SUBJECT: Engineering Review Comment
Mountain View Electric Association Inc. (MVEA)

Project Name: High Forest Estates Filing 1 – Replat

Project Number: VR2311

Description: A replat of Lot 1, Block 7, Willow Springs Estates to development
2 residential lots located at Walker Rd. and Table Rock Rd. in Township 11S, Range
65W, Section 10.

MINOR SUBDIVISION PLAT  
 HIGH FOREST ESTATES SUBDIVISION  
 FILING NO. 1

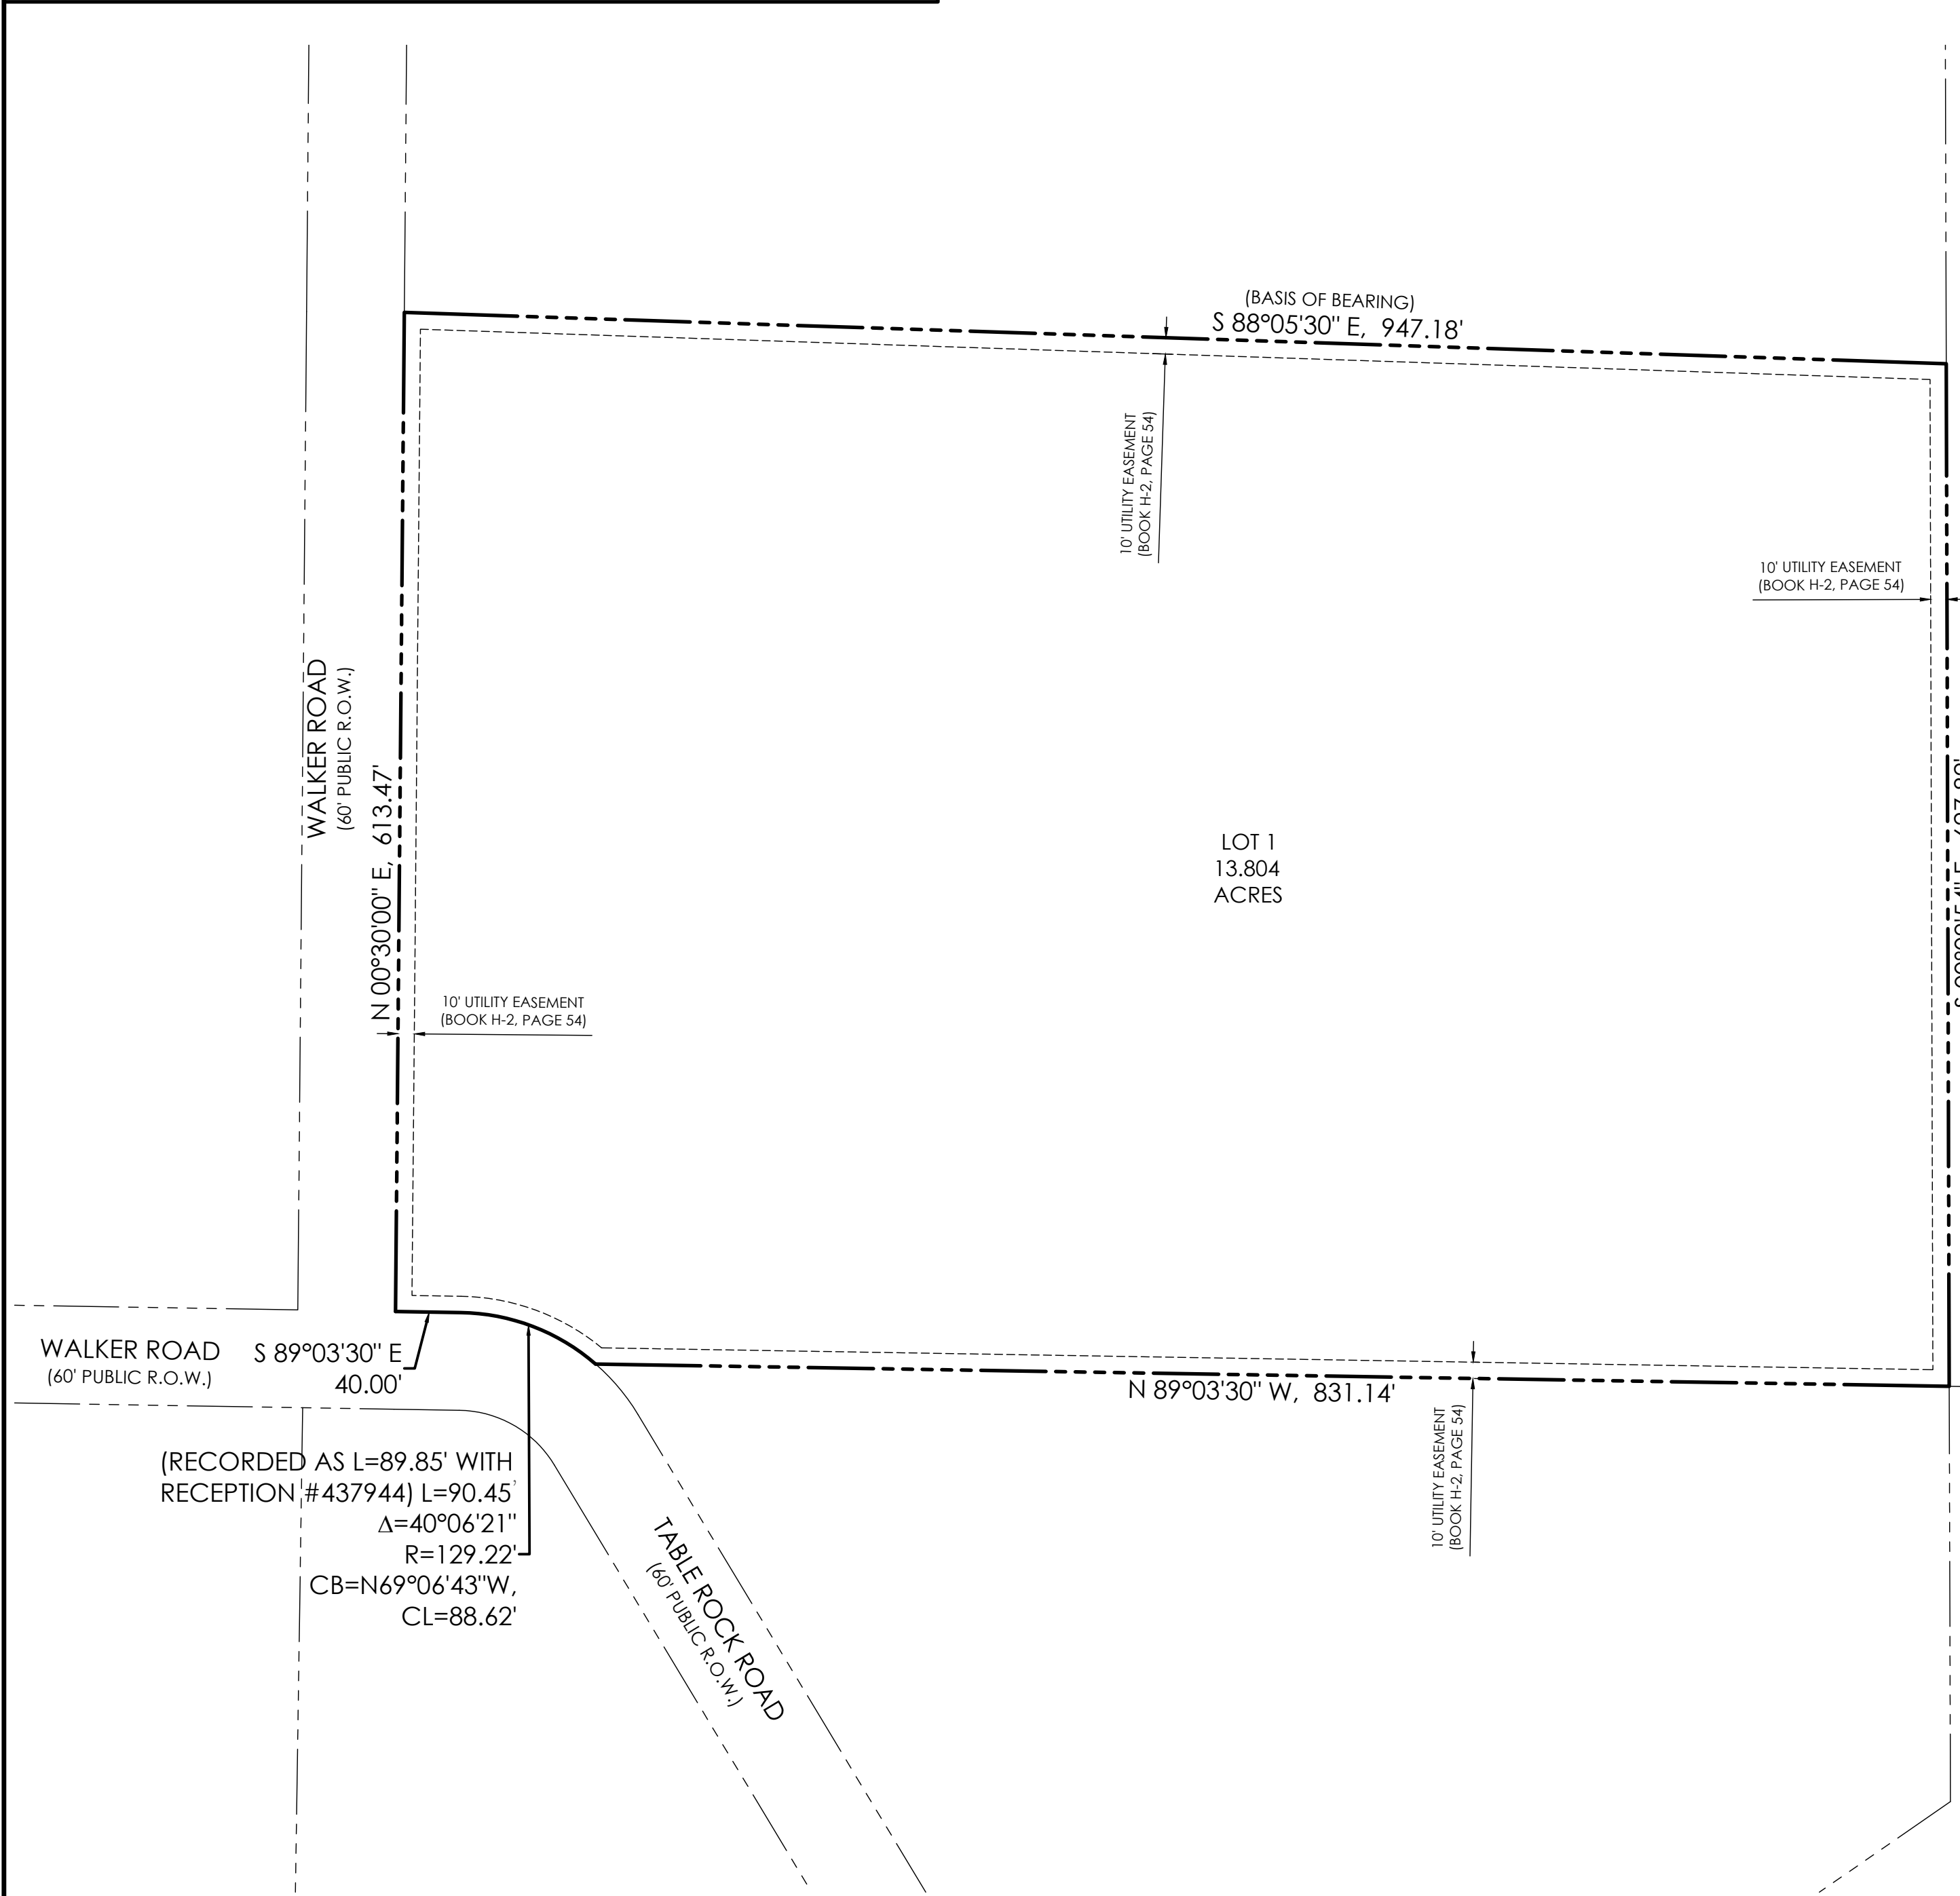
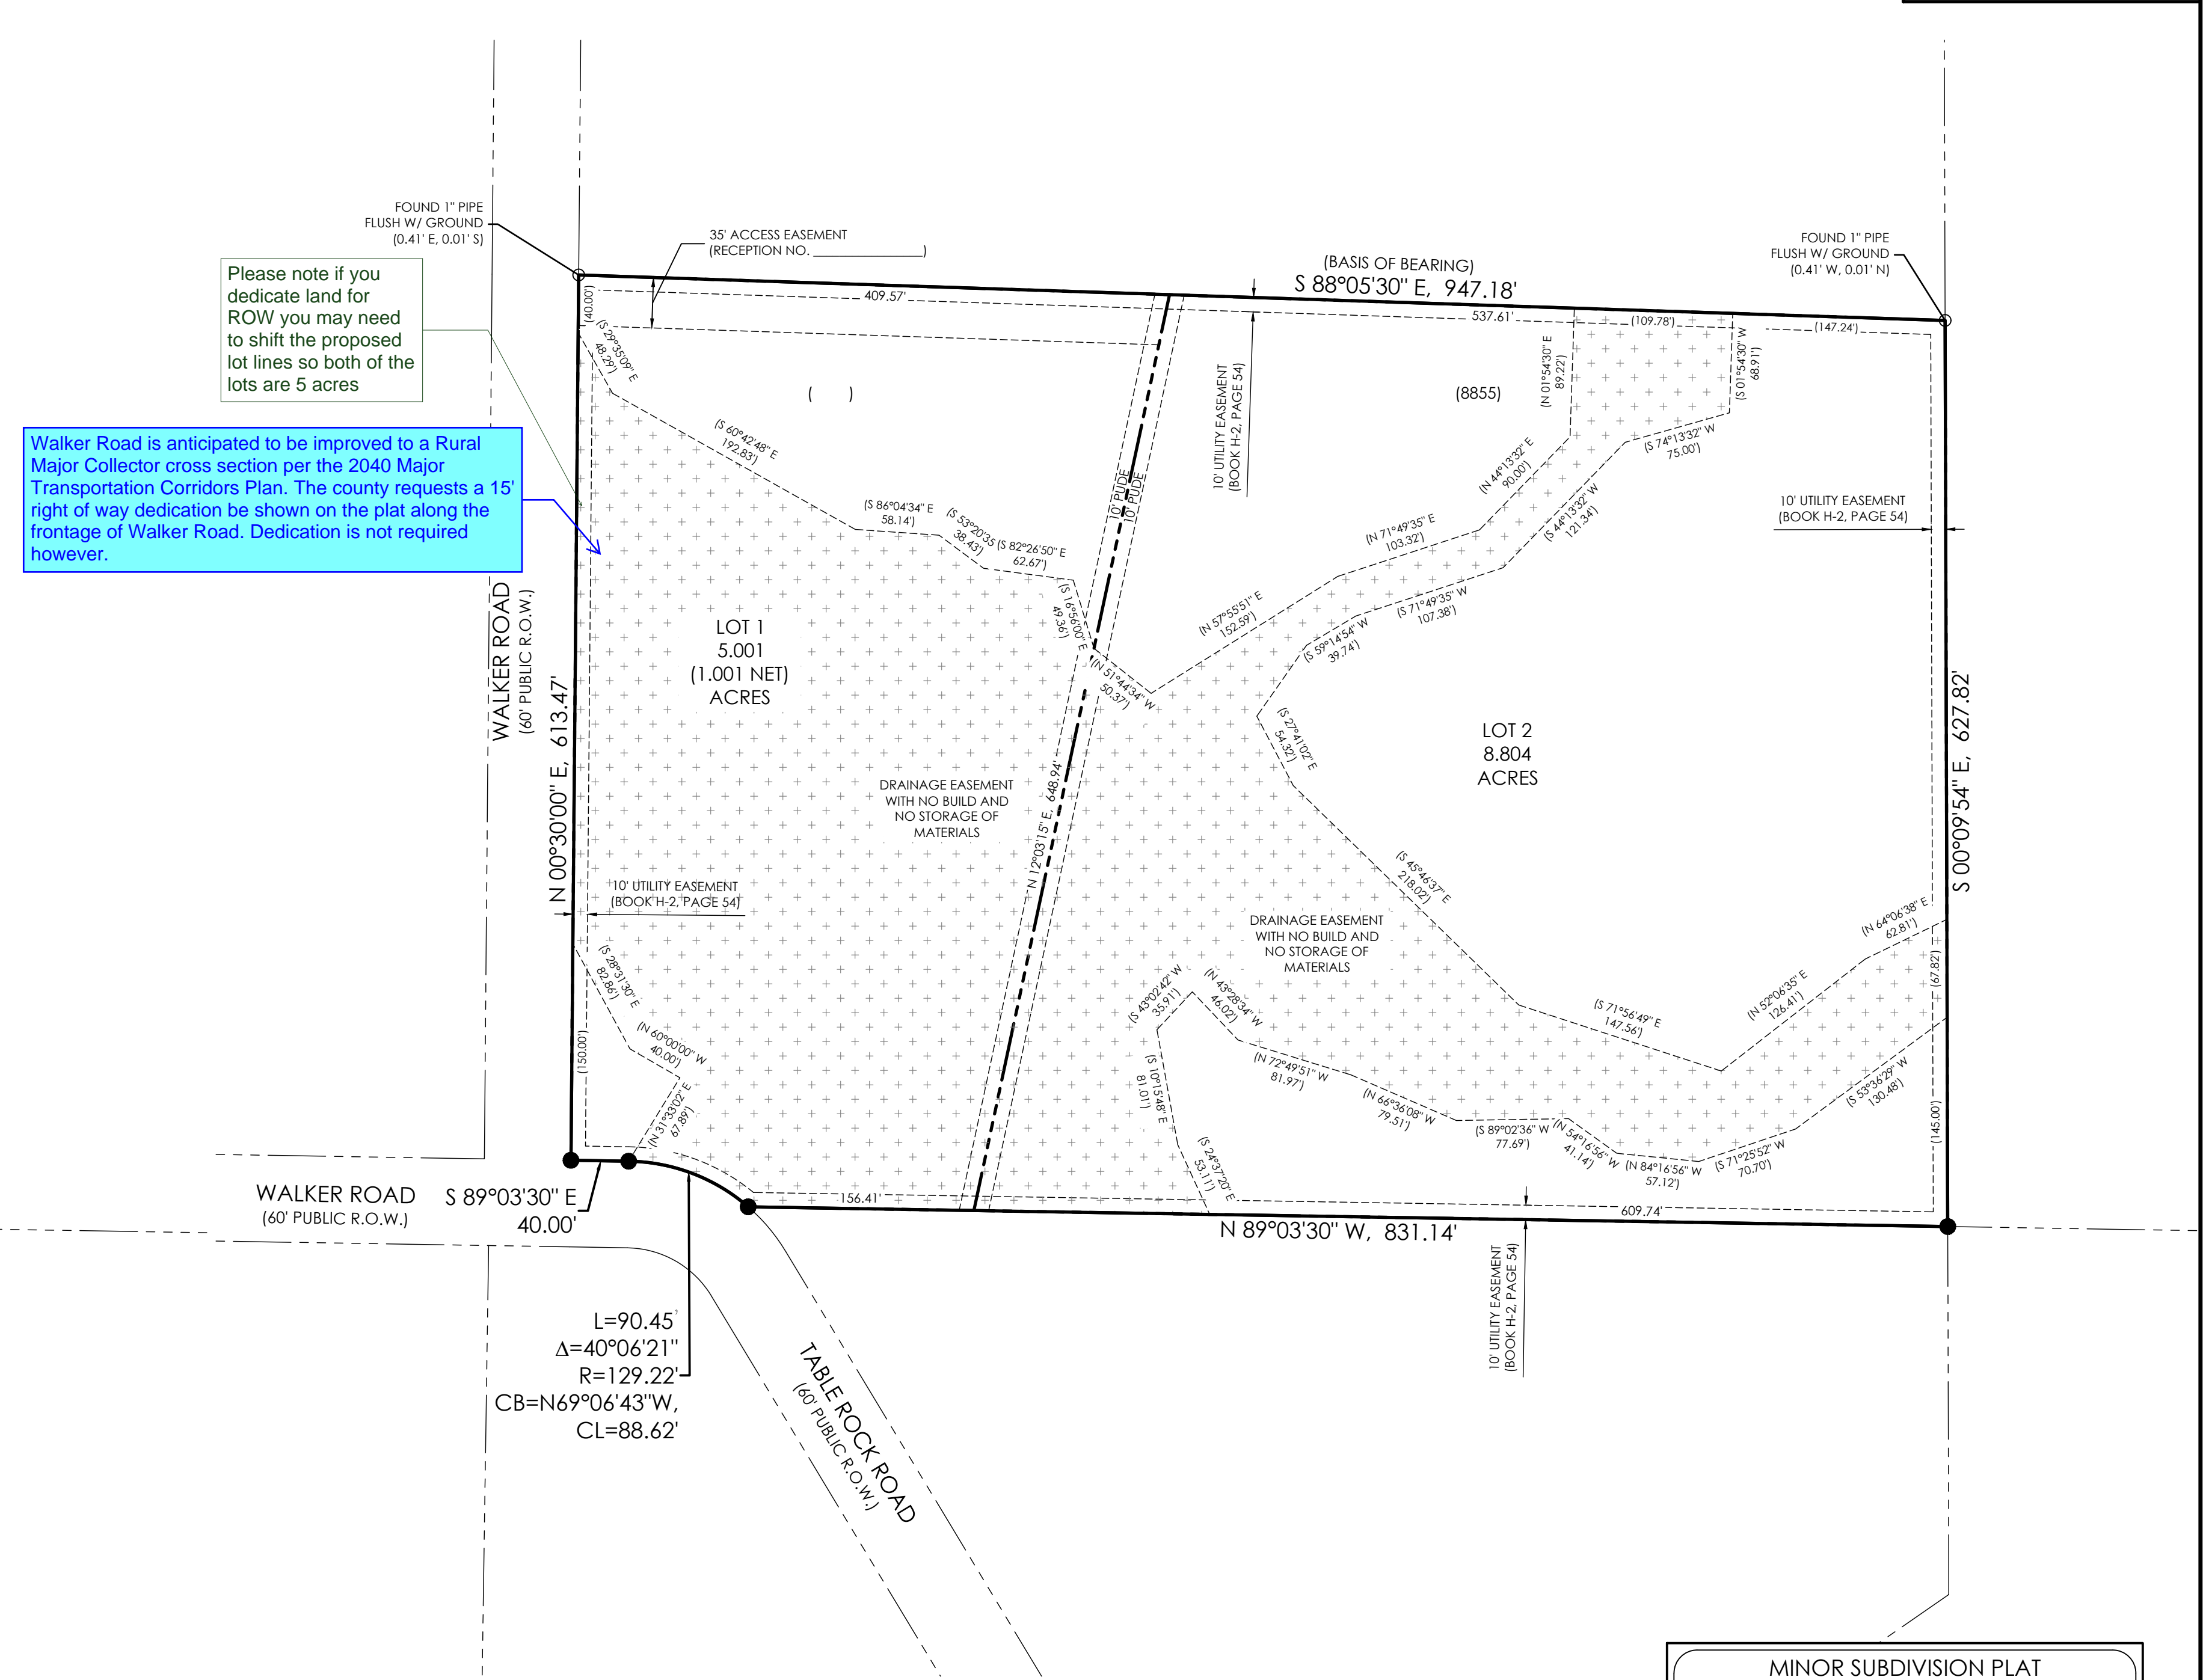
MVEA requests ten (10) foot front, side, and rear lot utility easements on the plat, adjacent to any public improvement easements. MVEA also requests the platting of MVEA's existing facilities with easements on the plat. Additional easements may be required.
